From: Billington and Langho Parish Clerk <blparishclerk@outlook.com>
Sent: 26 June 2018 19:39
To: planning
Subject: 3/2018/0506

Following the meeting on 25th June 2018 the Parish council wish to lodge the following objections to 3/2018/0506. This is a re-submission of 3/2015/0880 to which the Parish Council submitted objections. The Parish Council objects to this application for the following reasons:-

Project No: SIMPS/01B Dwg 03 Drawn: JD

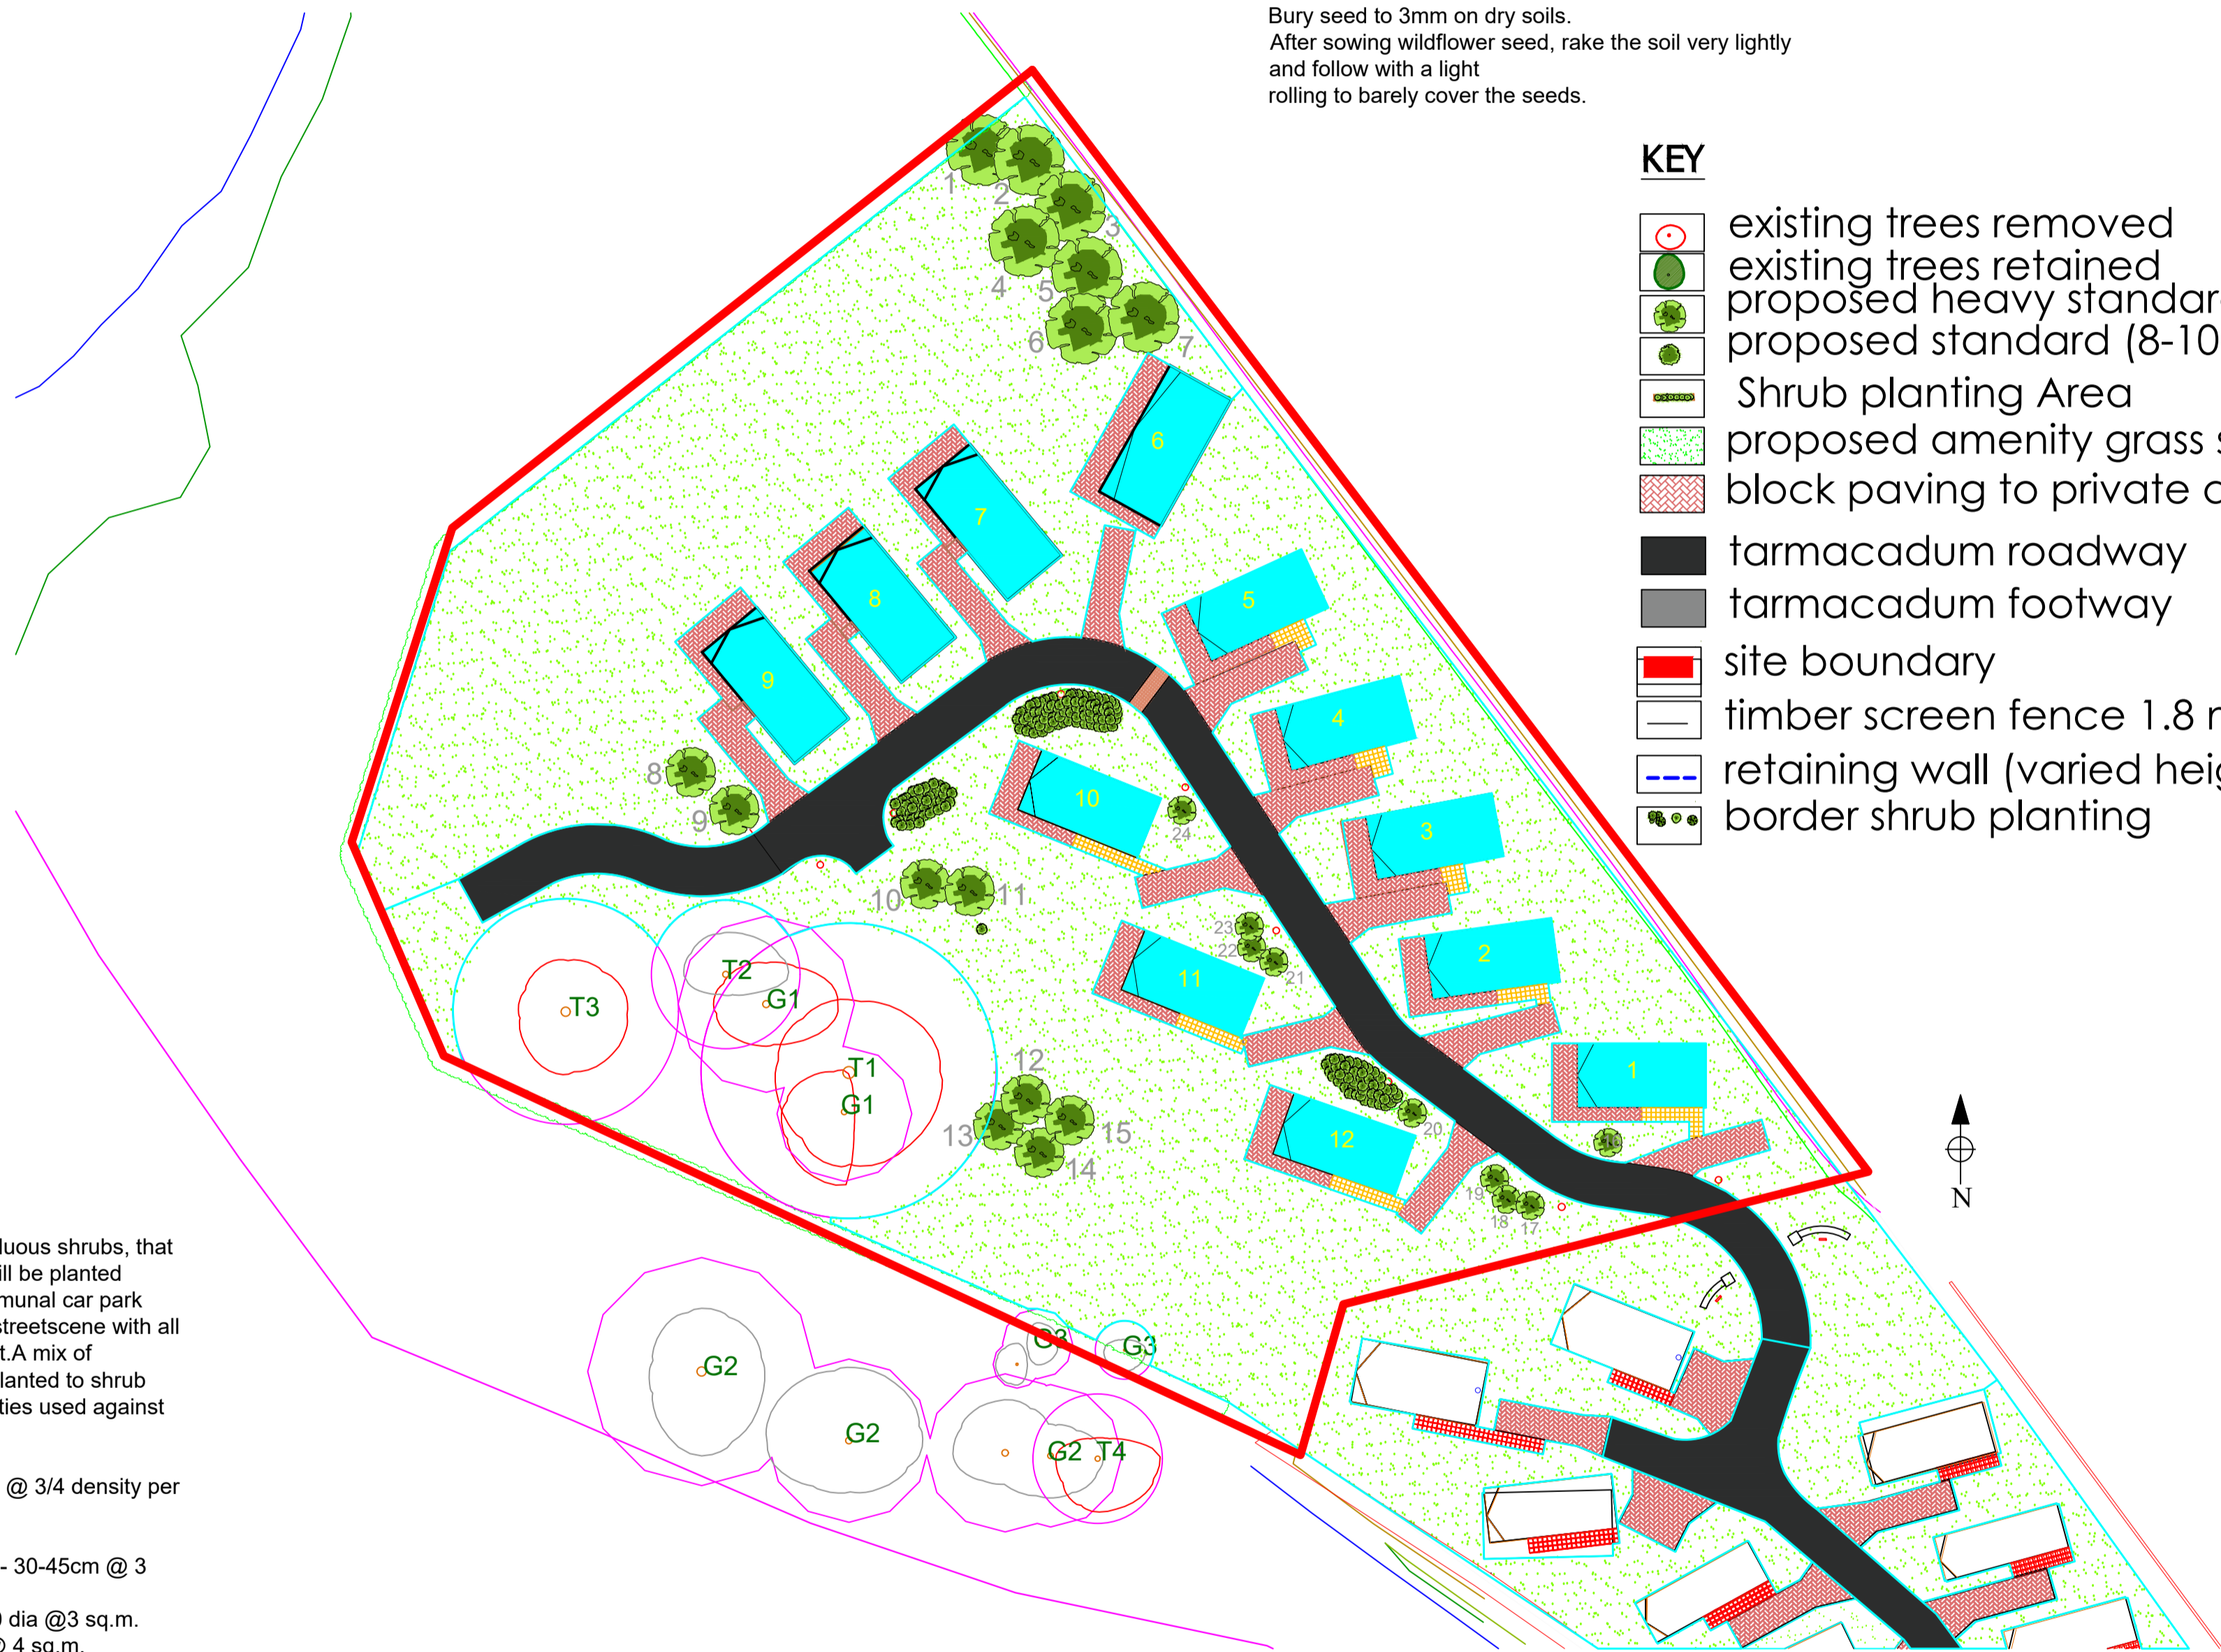
1. Concern for local infrastructure.
2. Unauthorised elevation of site,
3. Creep development
4. Access to and from the site
5. Height of the elevations and the detriment to the adjoining properties.
6. The topsoil and other materials that have exceeded the site boundaries
7. The noise from the site as landscaping requirements have not been adhered to.
